Director, Transport Assessments, Planning Services
Department of Planning, Industry and Environment
GPO Box 39
Sydney NSW

Application SSI 7485

I am, therefore, writing in relation to the proposed modifications to the M4-M5 Link, Mod 2; The Crescent Overpass and changes to pedestrian infrastructure in North Annandale, Rozelle and Rozelle Bay Foreshore area.

Figure 4-4 Elevation: Indicative view of The Crescent overpass

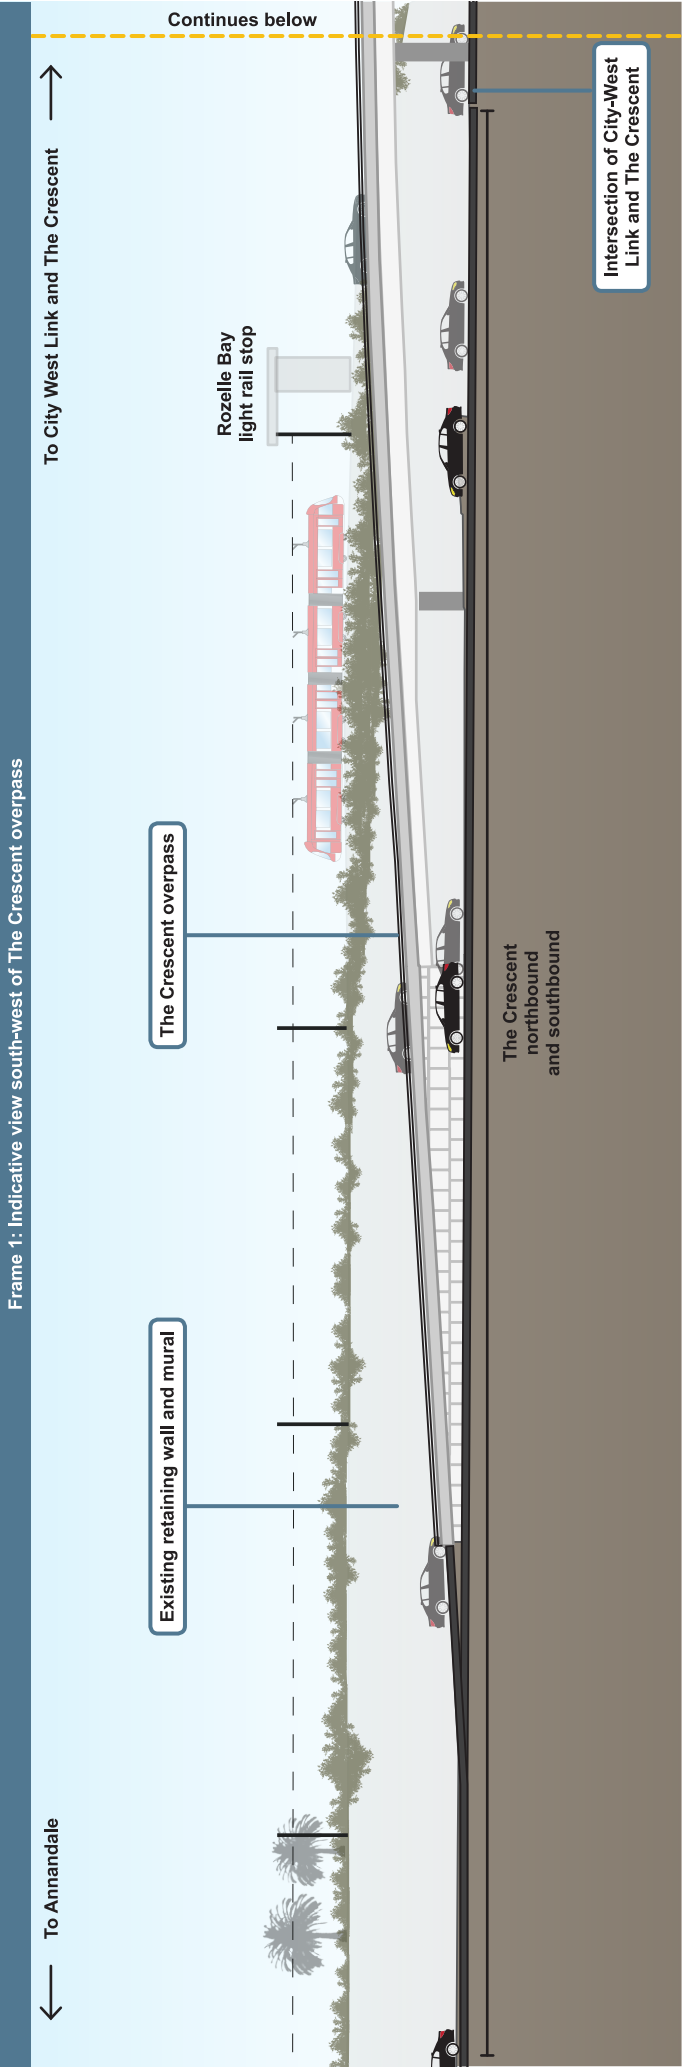
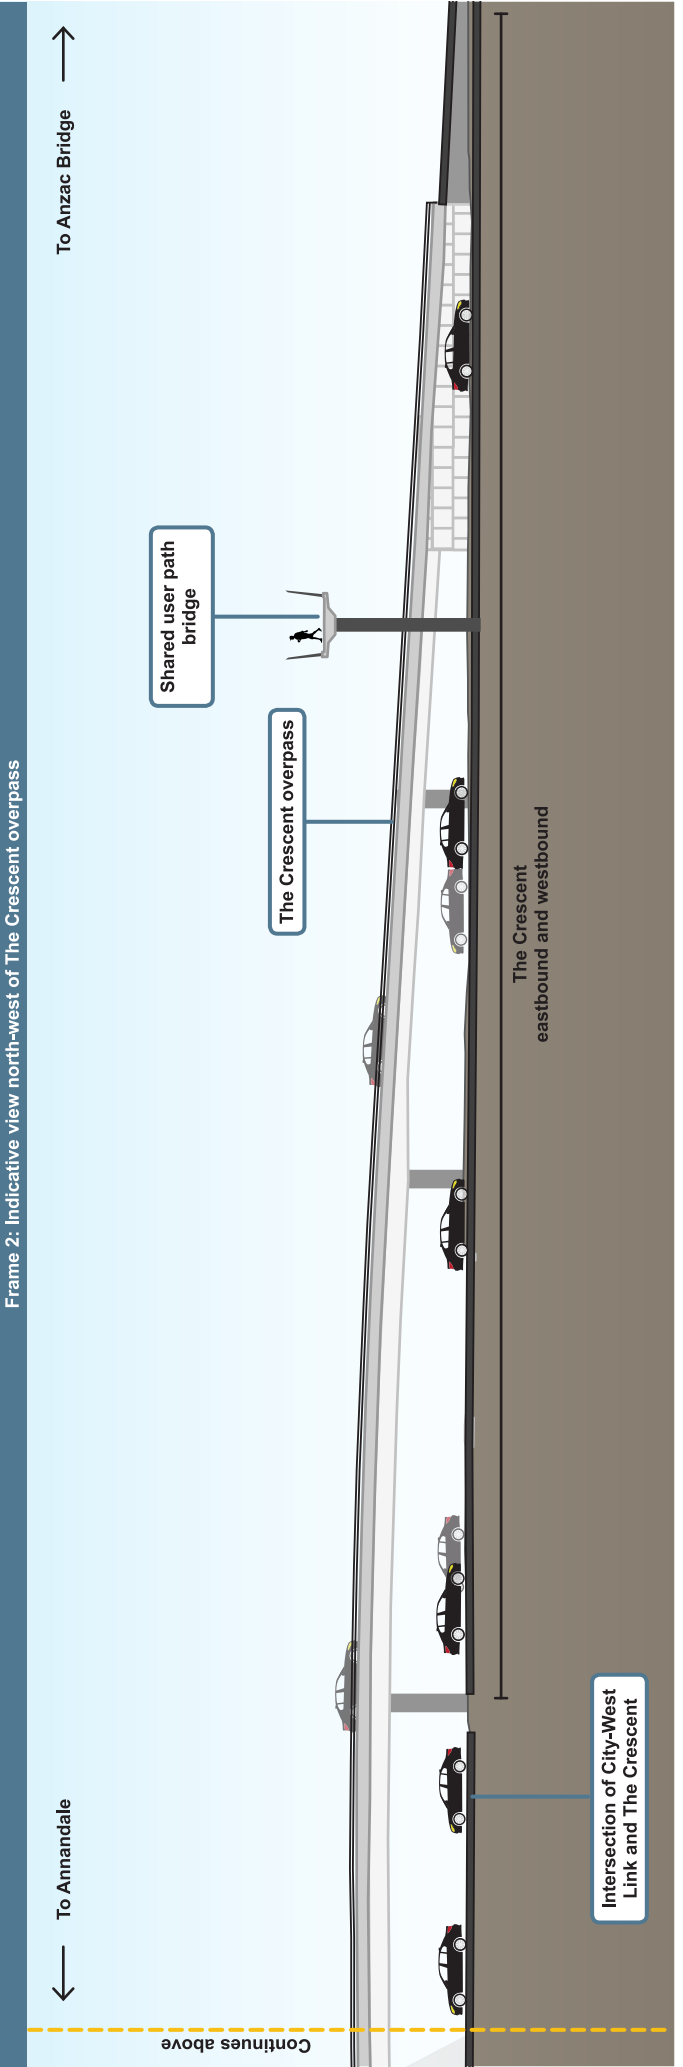
The 10 m high concrete overpass blocks views, broadcasts noise, breaks faith with residents and is contrary to the government’s undertakings that the structure would be underground. It is not going too far to say that it will be an eyesore.

The 10m high concrete structure that will be the overpass destroys most of the “Green link” concept in one fell-swoop. It blocks direct access to the foreshores. It forms a massive physical and psychological barrier to connectedness.....and it’s not green. (If the

base of the structure is 8m above the Western Distributor, then the complete structure will stand about 10m above the lower road).

Figure 4-5 The Crescent/Johnston Street/Chapman Road intersection

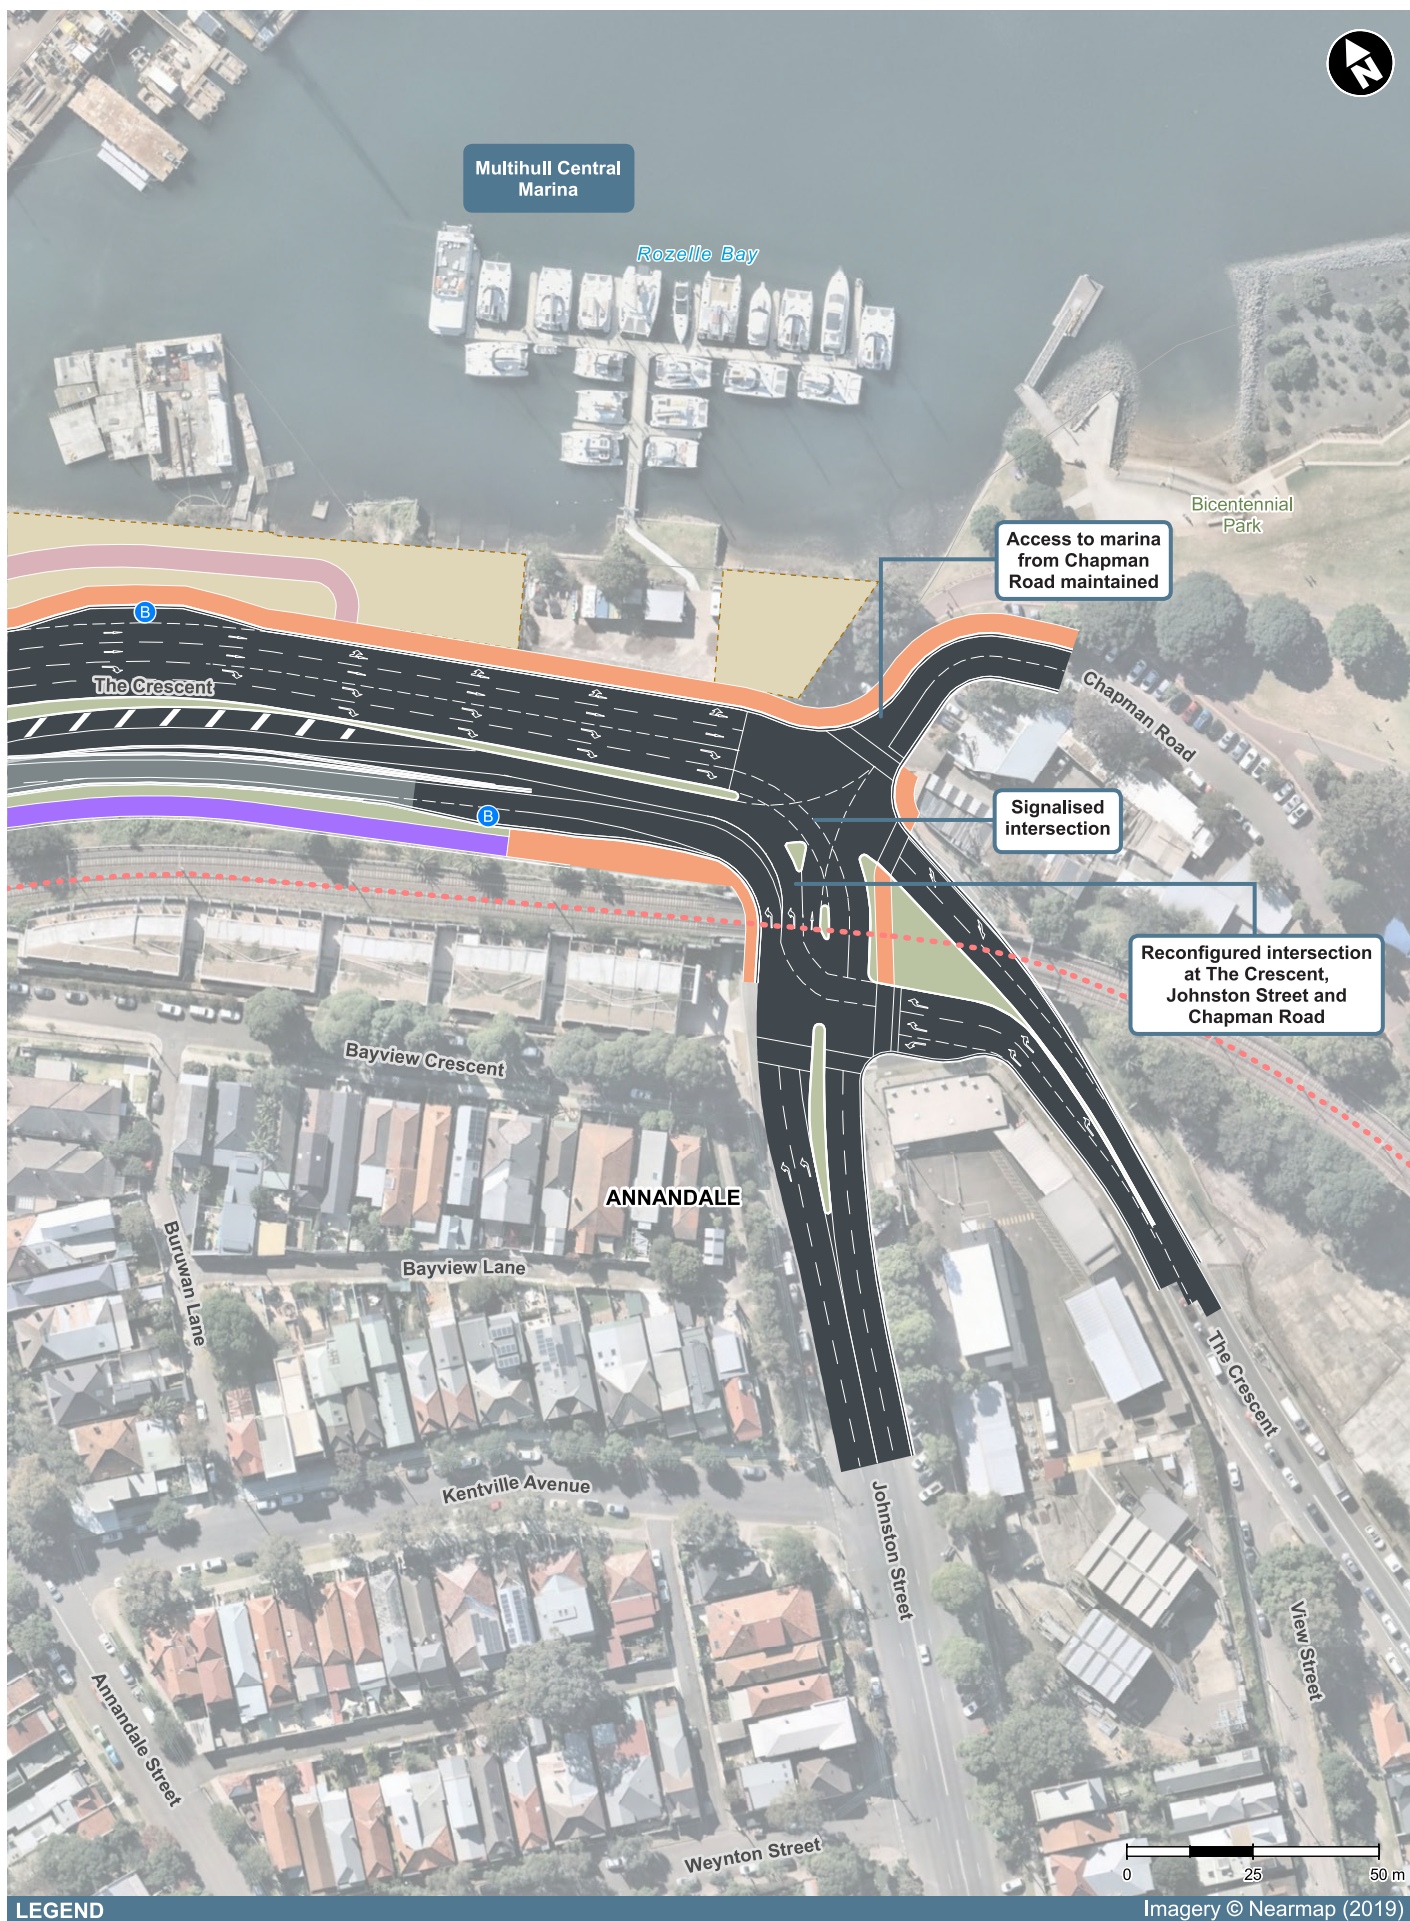
The traffic planning around the intersection of Johnson Street and the Crescent is so complex (bad) that, a magnified version of the map had to be supplied. See below.

If we need a magnified version, then the planners really need to go back to their drawing boards. A little more creativity is required. (Perhaps the brick pylon could be replaced with something smaller, for example). The ramifications for children trying to get from Rozelle to the Blackwattle Campus of Sydney Secondary College, or trying to get to Saint Scholastica school, Glebe, are that they will have to wait for multiple sets of traffic lights (maybe waiting for about 6 min in total)...or be tempted to “run” the lights.

Vehicles that currently have the option of turning right from Johnson Street into The Crescent will no longer have that option. We will still have the problem that traffic travelling north along The Crescent will not be able to see around the brick pylon that supports the light rail at this intersection.

Vehicles travelling north from Annandale will no longer be able to turn right into James Craig Drive.

Figure 4-7 Elevation: Indicative view of the shared user path bridge

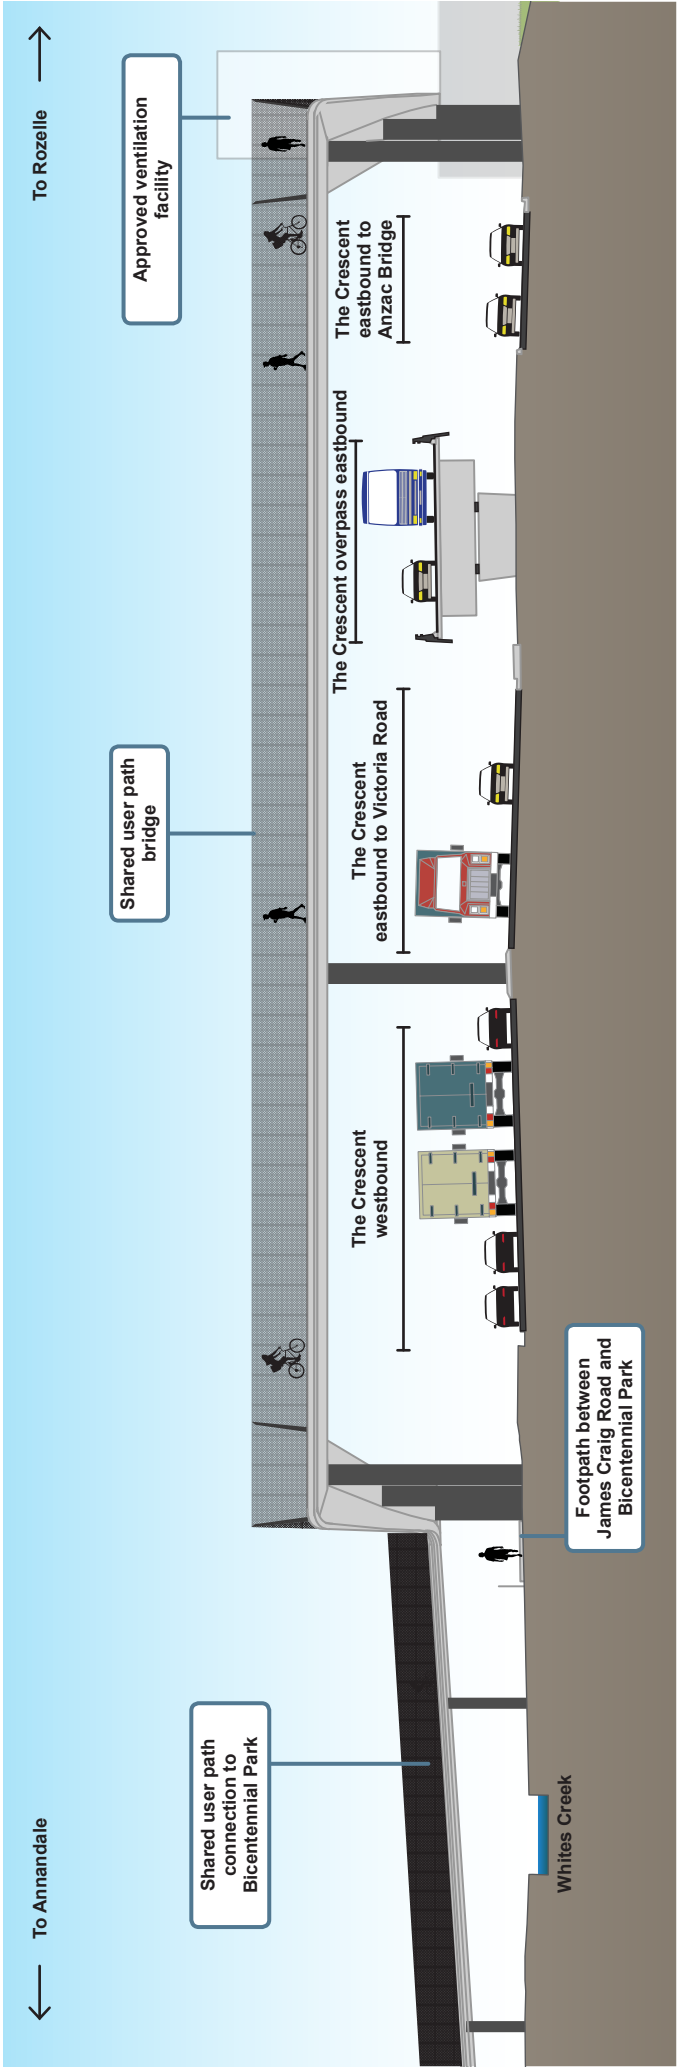
Additionally, the proposal for a very long, very high, shared pedestrian/bike overpass on the Eastern side, to Rozelle Bay foreshore will give access to the foreshore without having to negotiate ground level traffic lights but it has a lot of drawbacks: it effectively doubles the direct distance across the Western Distributor, it is relatively narrow, it is certainly not green, it is visually unattractive, because it is so high it blocks views to the bay, and it means a rather stiff climb for bikes and wheelchairs or elderly people.
